Case Officer: Linda Griffiths

Recommendation: Approve

Proposal: Change from one single central flue on the academic building to several which would be 300 mm higher than those previously approved plus changes to the design of the approved weed garden, including the addition of a ramp, relocation of the sink and events area and a material change of the main access path from Colas Fibredec to stone crazy paving (proposed as non-material amendments to 21/03150/REM)

DRAWING NAME:
PROPOSED ELEVATIONS - ACADEMIC BUILDING E-W

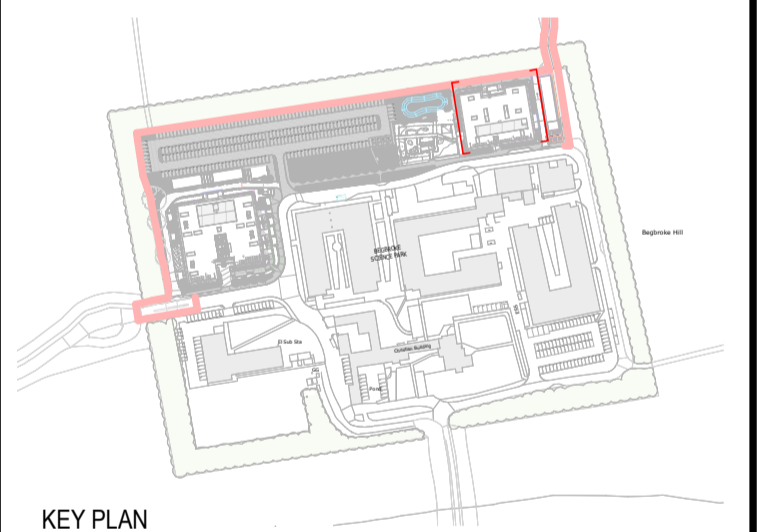
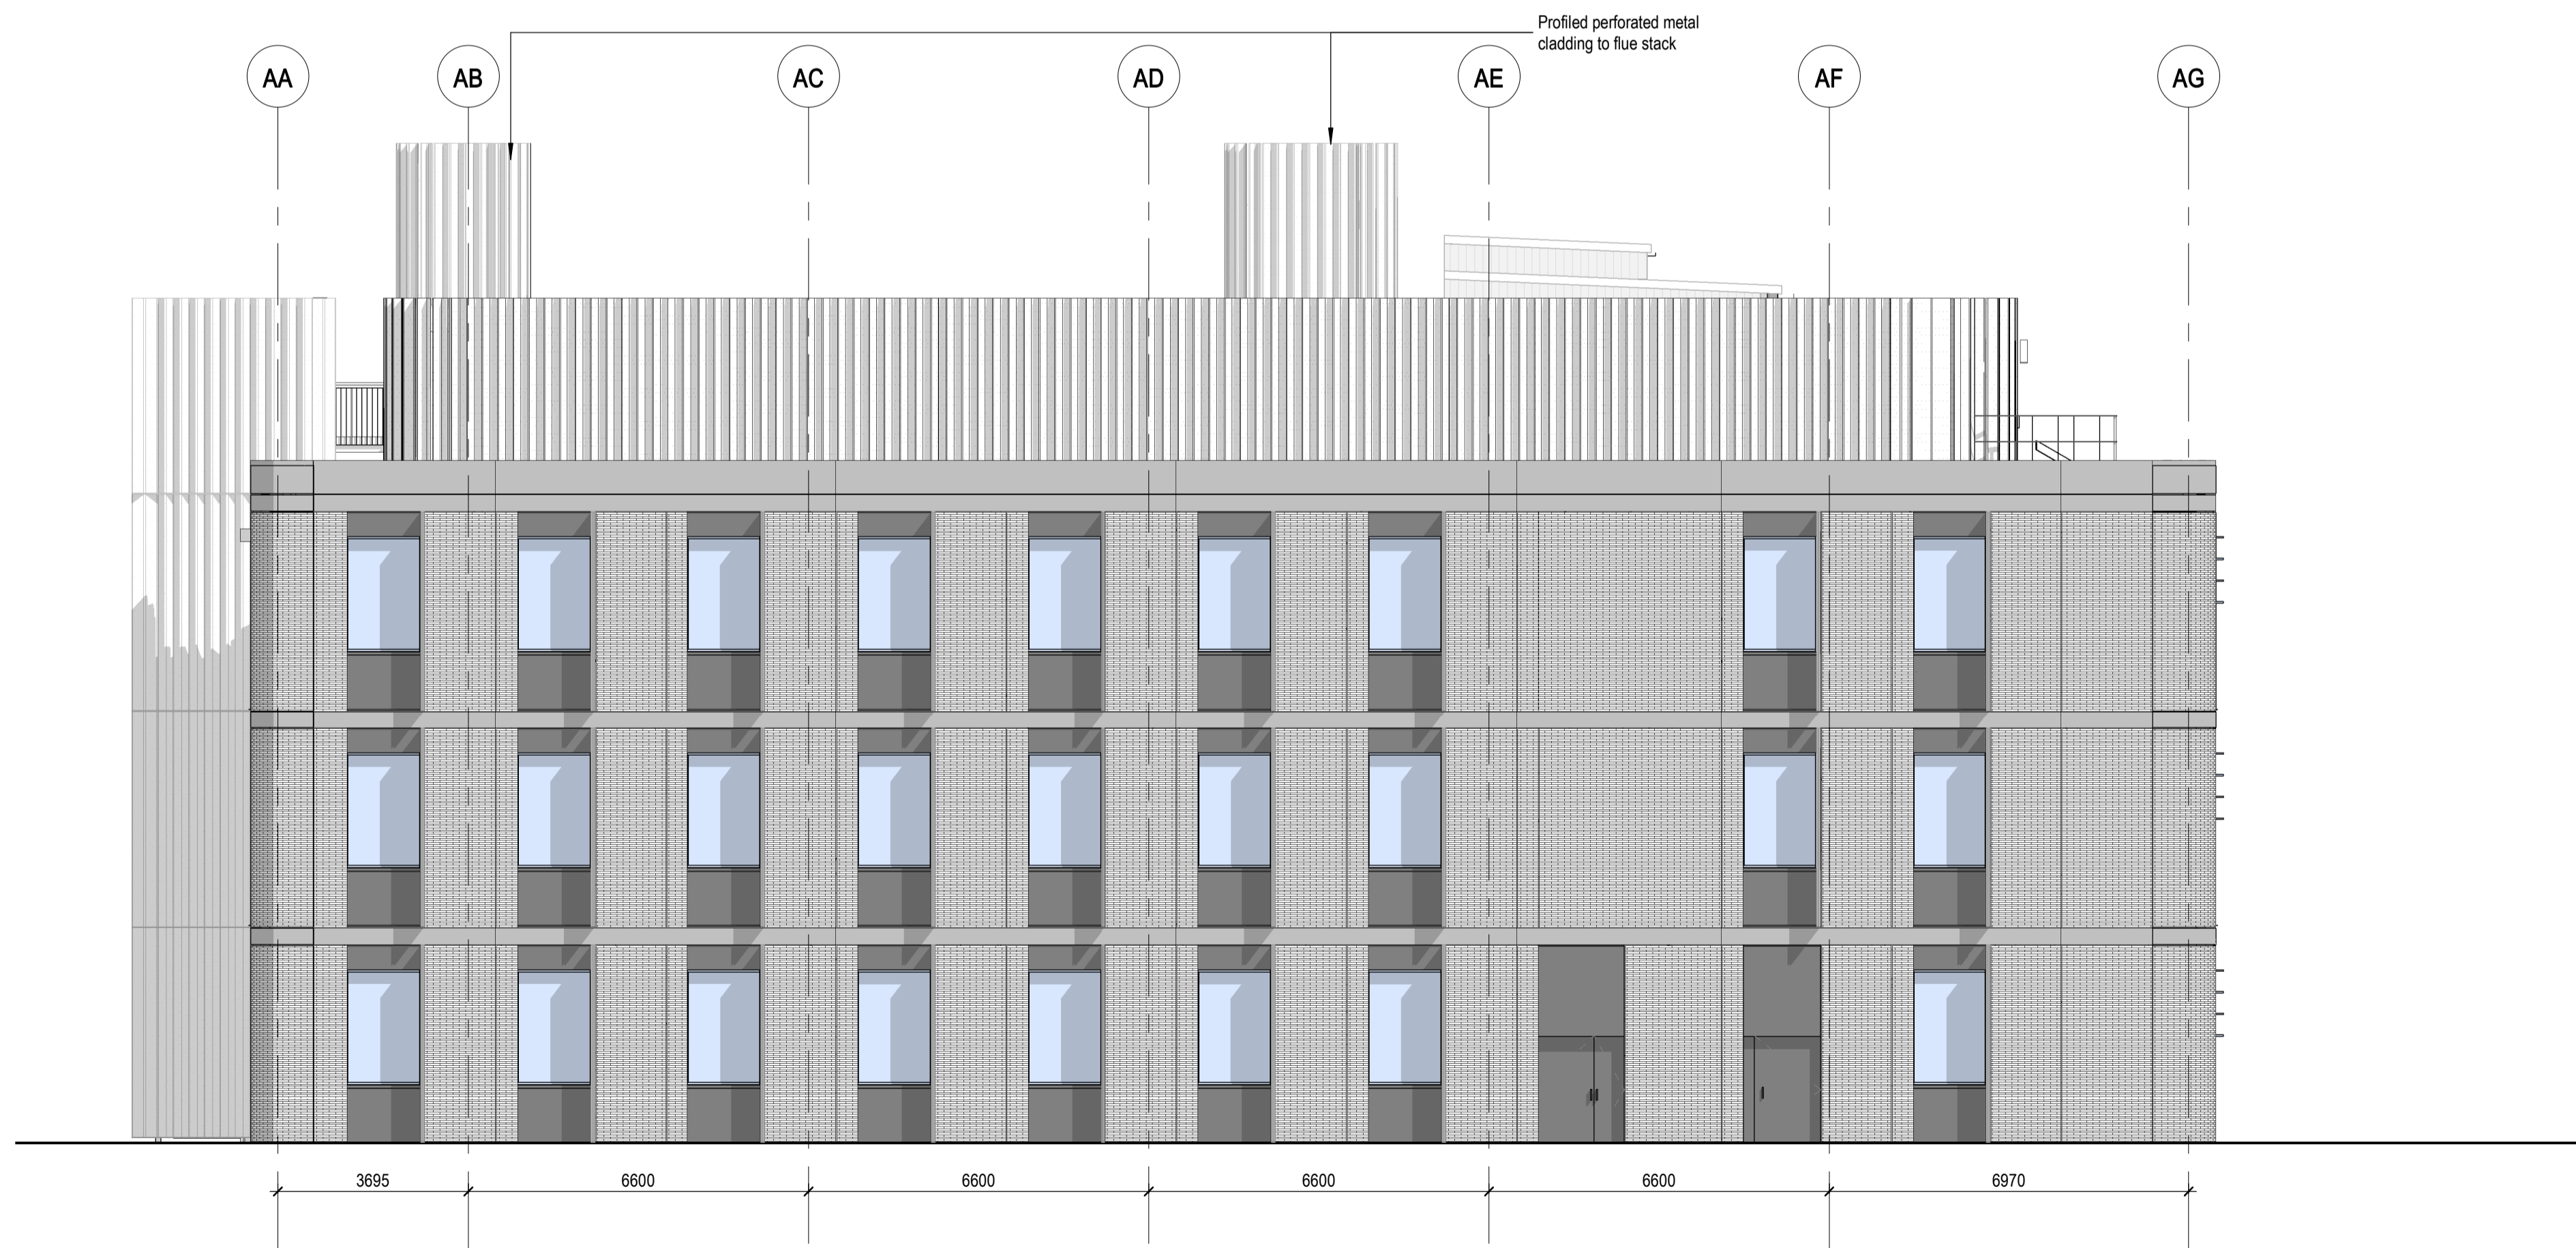
- 2.1. The applicant's agent advises that as the detailed design has progressed, it has become apparent that there is an operational need for several flues on the roof of the academic building rather than one single central flue and these would also need to be 300mm higher than previously approved.
- 2.2. In addition, the design of the Weed Garden has changed as a consequence of responding to the wider Begbroke scheme. Due to an identified level change of 280mm on the eastern side of the site, a gentle ramp from the east into the site is now required.
- 2.3. The main access path through the centre of the site has changed from Colas Fibredec to stone crazy paving, a material which can be locally sourced.

- 5.4. The application is accompanied by a Landscape and Visual Addendum that concludes that the proposed alternative flues would be inconsequential in nature and the level of effects of landscape and visual receptors would remain unchanged from the approved scheme. There is no reason to disagree with this conclusion.

- 5.6. Having regard to the above, it is not considered that the proposed changes would materially impact the approved development and are therefore acceptable as non-material amendments.

**Drawing**  
Proposed External Elevations

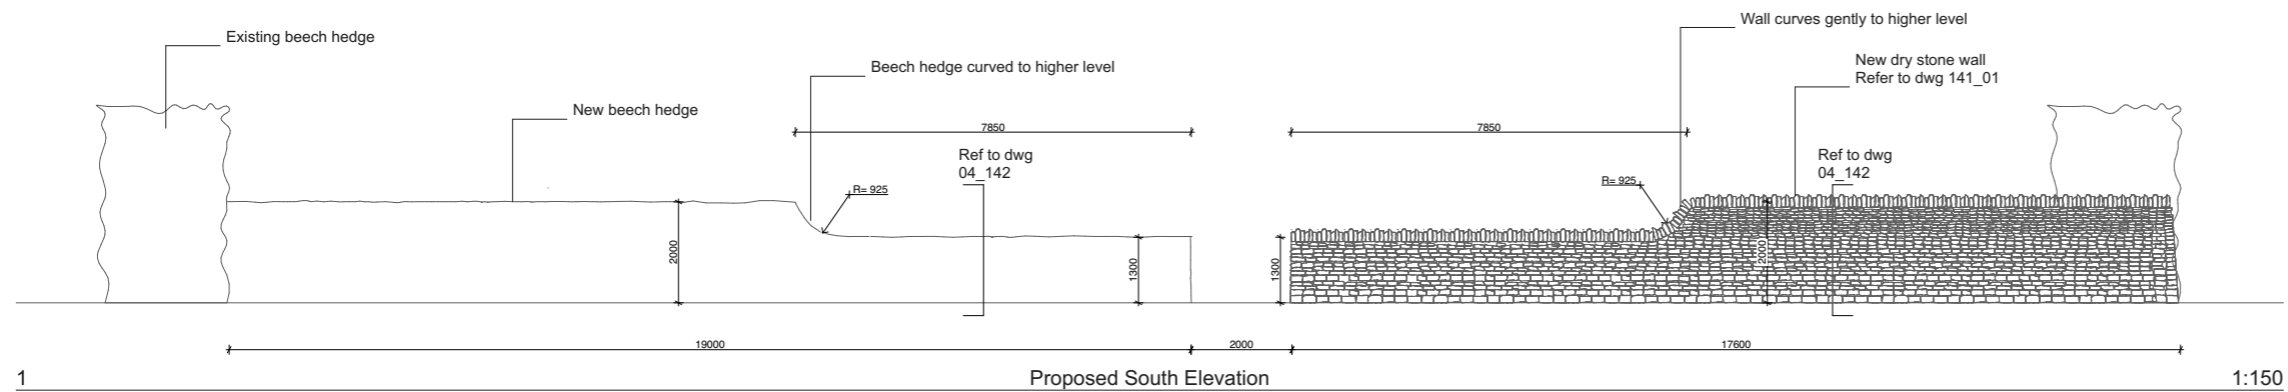
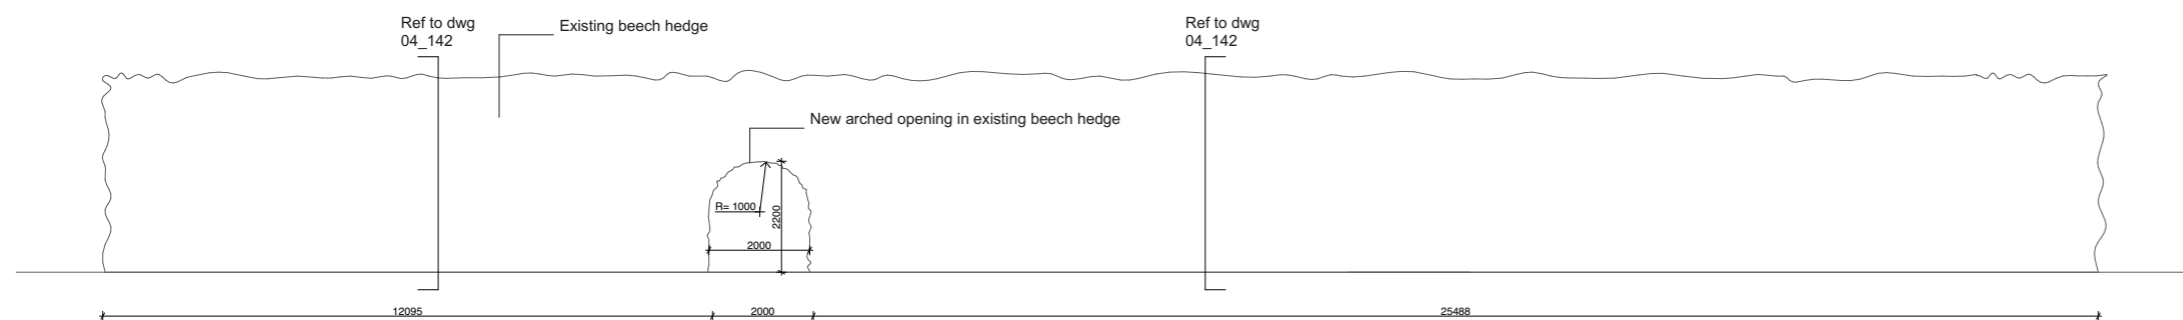
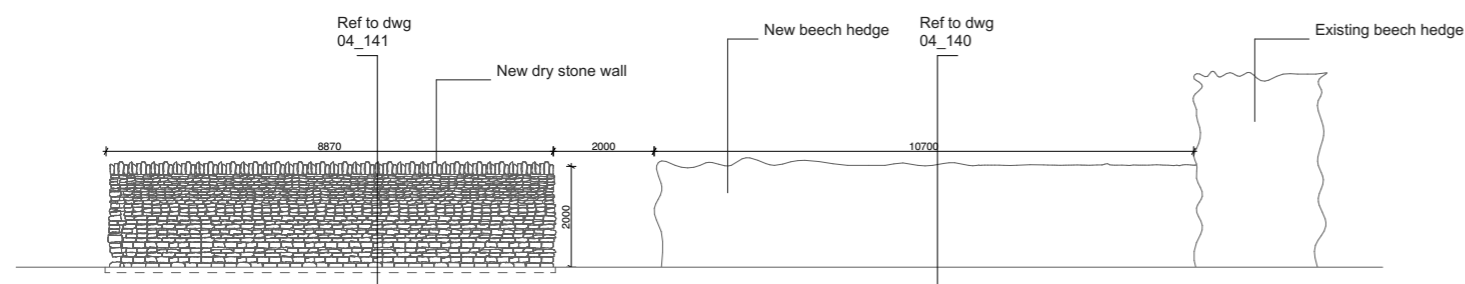
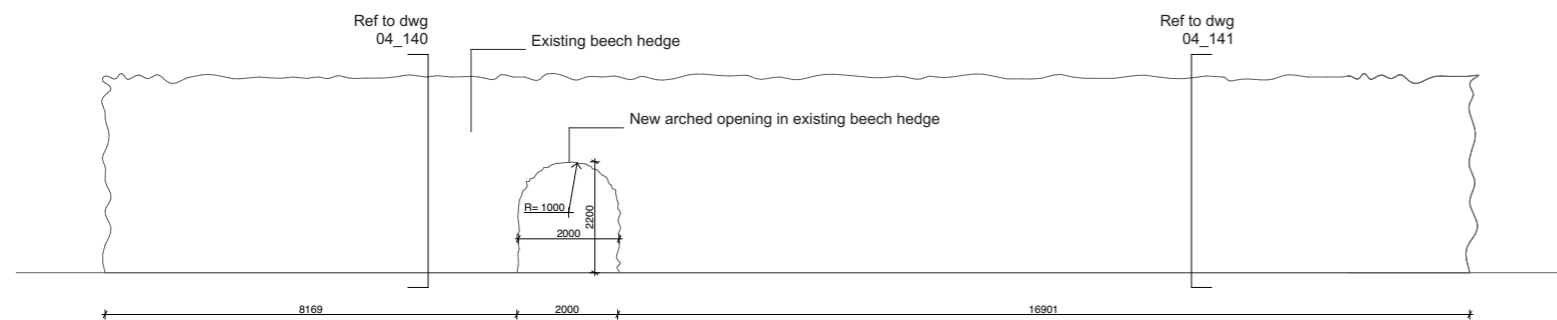
- 5.5. In addition, the proposed changes to the weed garden are needed for practicality and accessibility and do not materially affect the use, accessibility or appearance of the scheme.
